MDT-SF21026-R4-FDR.pdf Markup Summary

Subject: Stormwater Comments Color
Page Index: 1
Date: 2/2/2022 2:18:07 PM
Author: dotprete
Color: ■
Layer:
Space:
Page Label: 1

NORTH POND  
FINAL  
OUTLET DETAILS

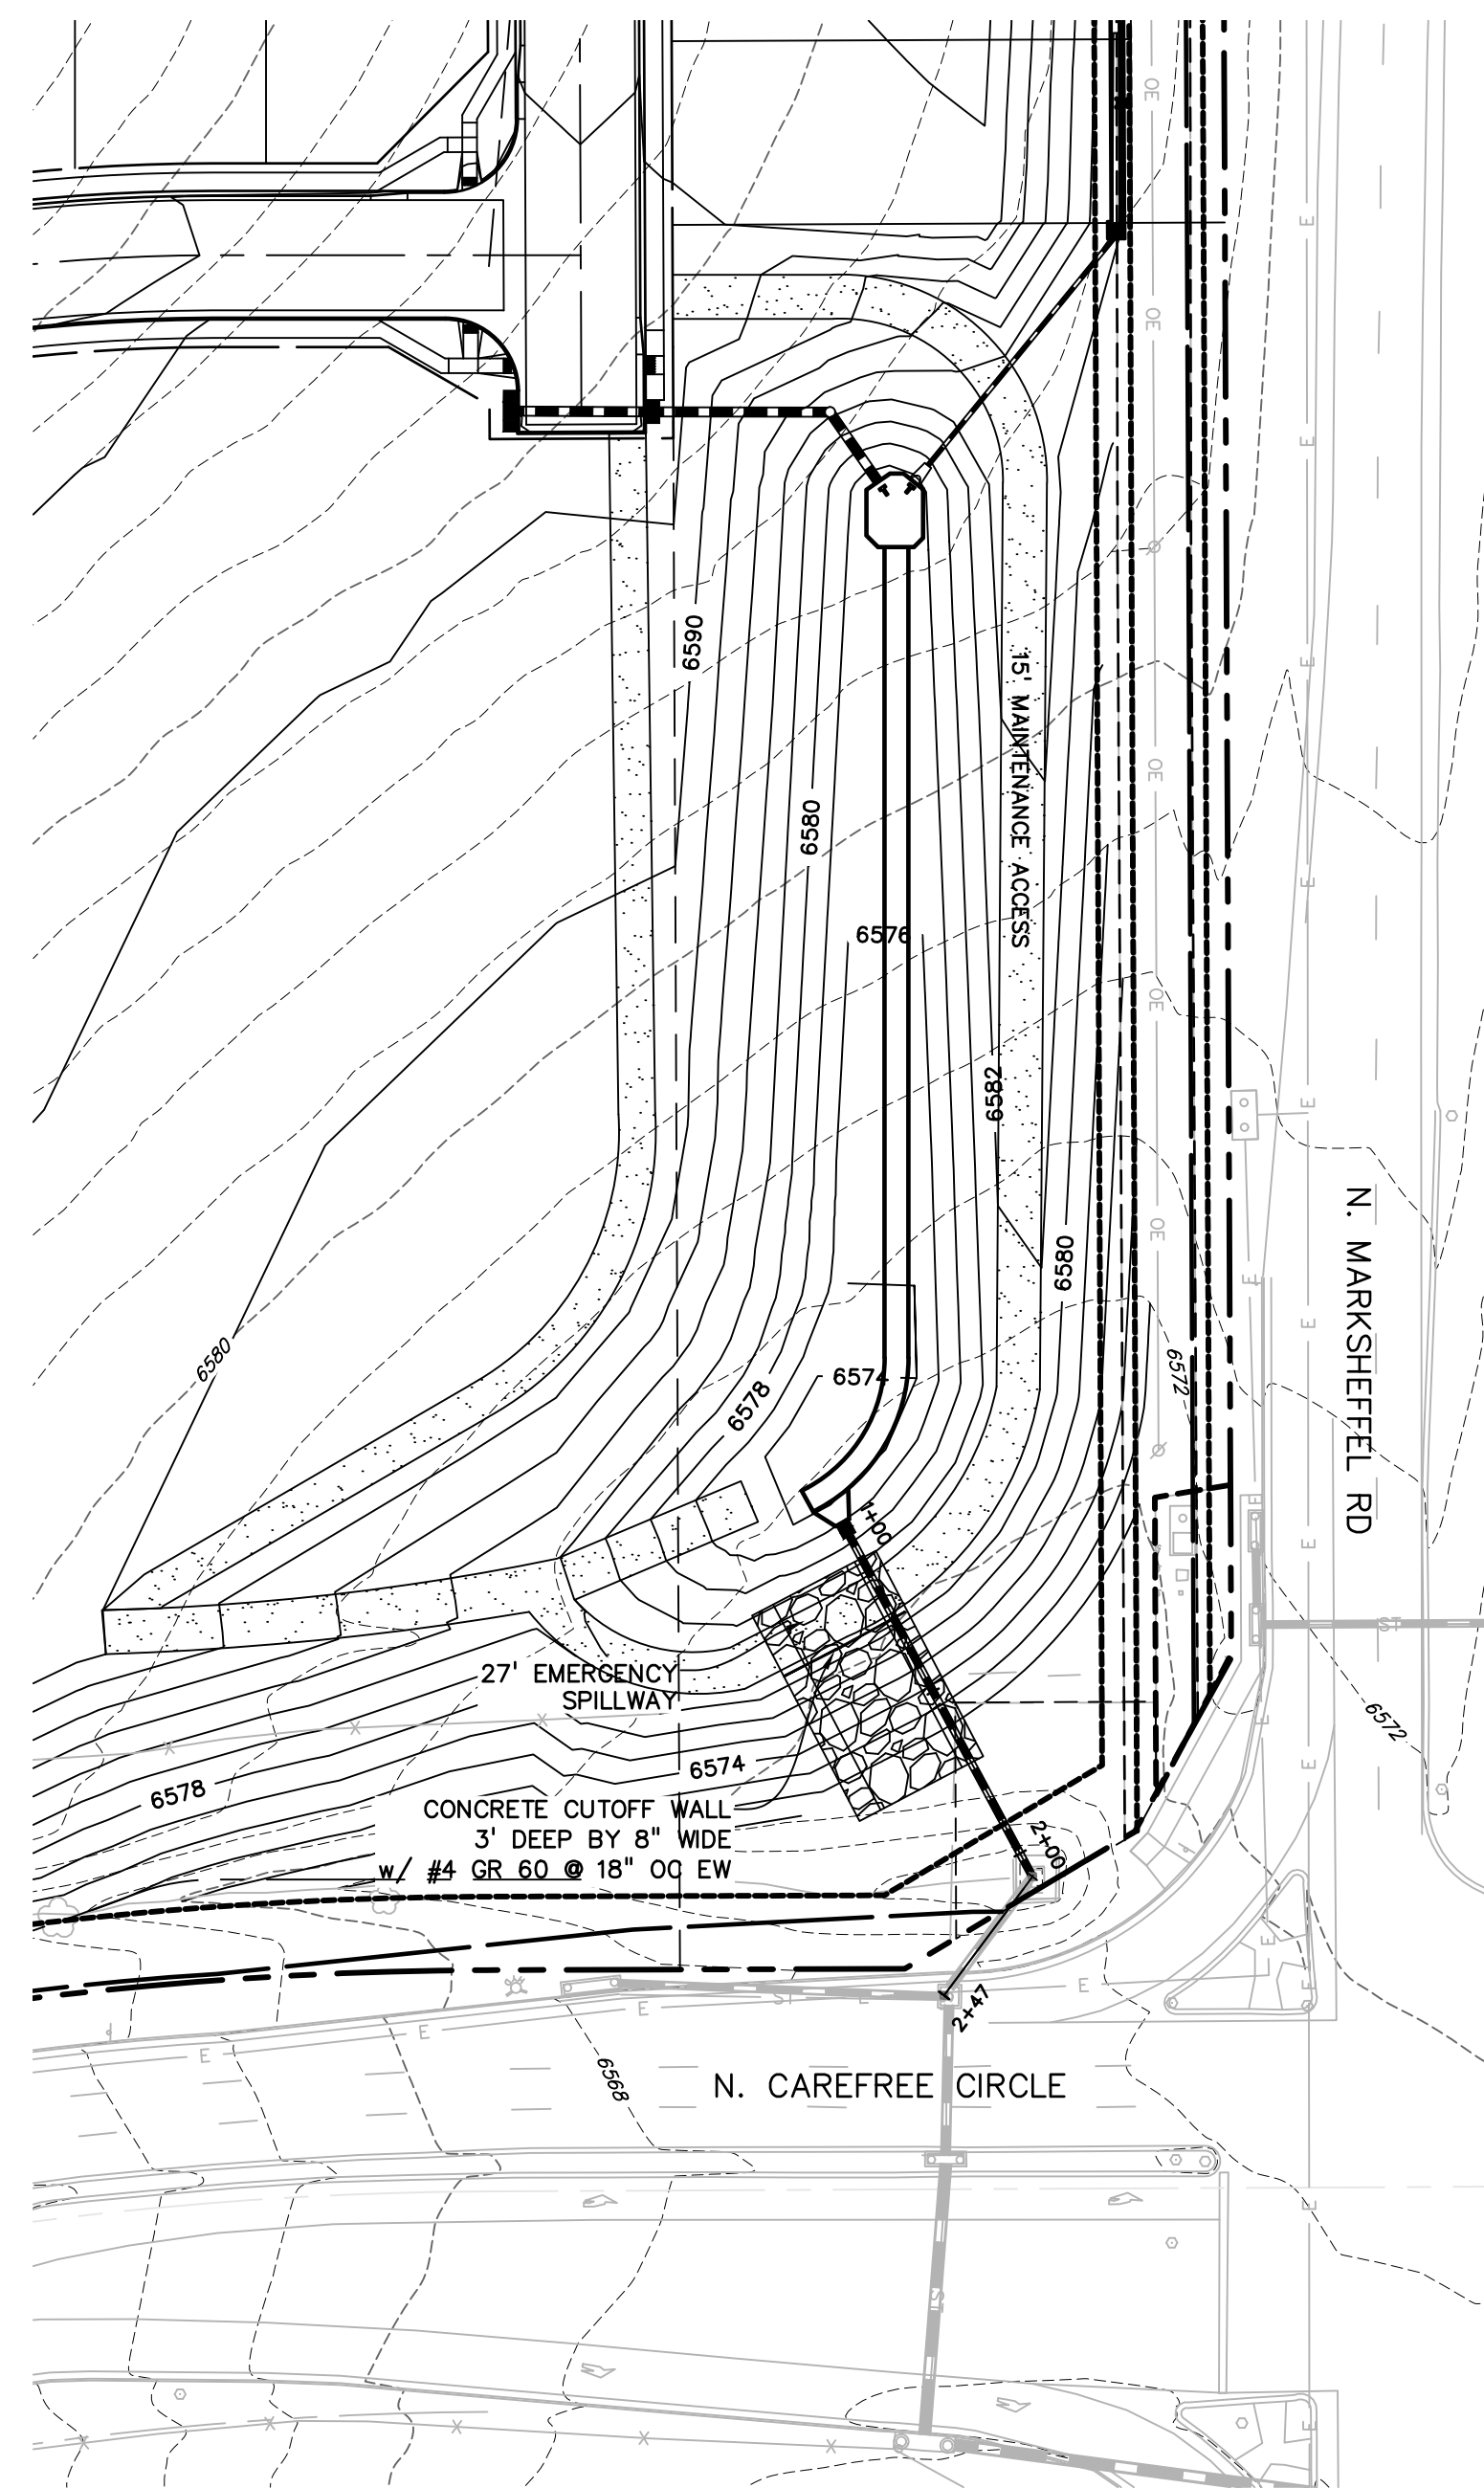
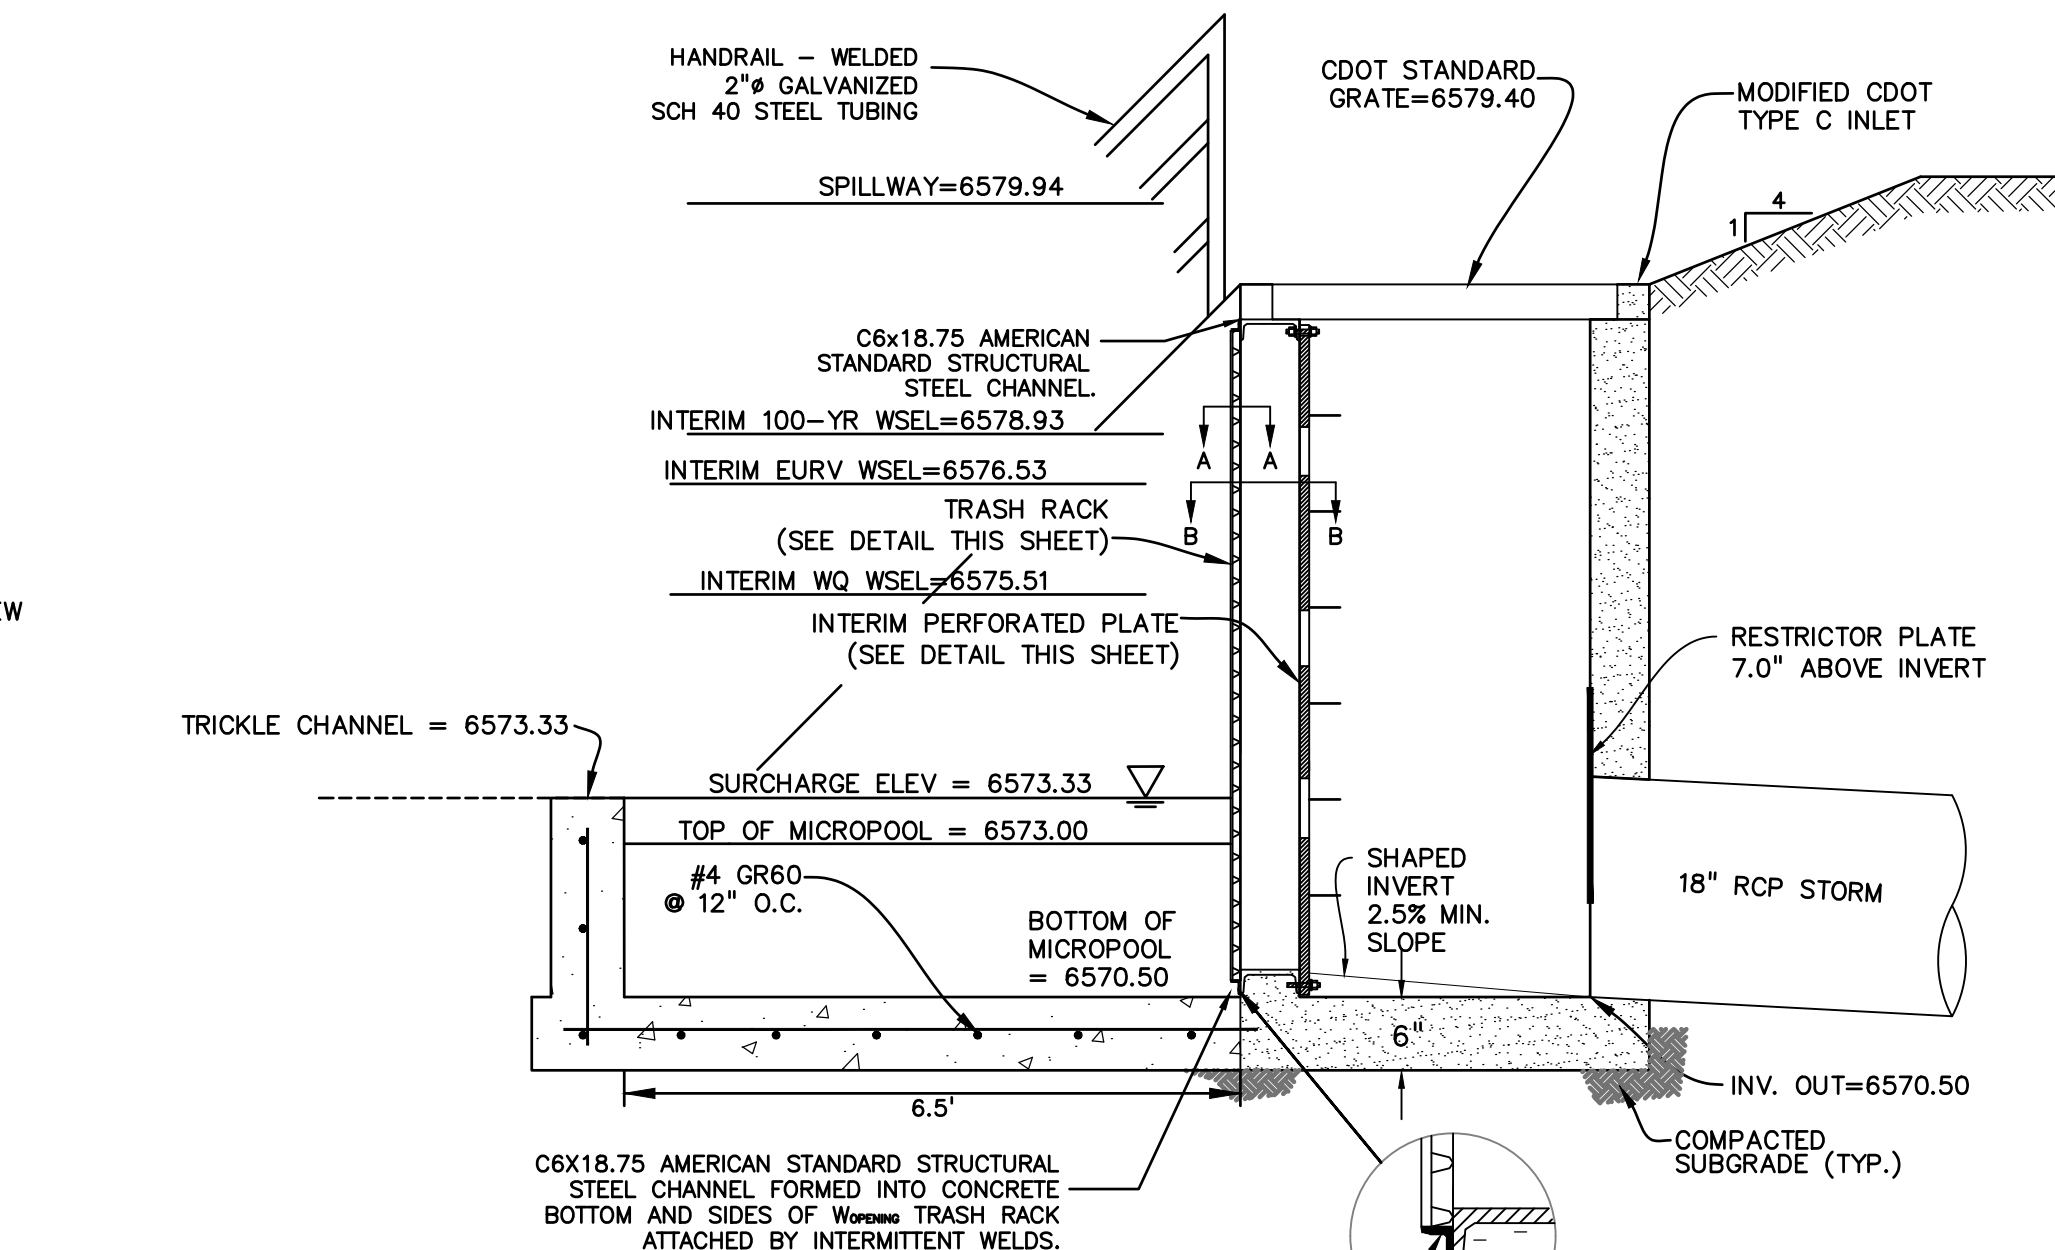
This should be ~1 Small adjustment to overflow weir elevations should get to the requirement

This should be ~1 Small adjustment to overflow weir elevations should get to the requirement
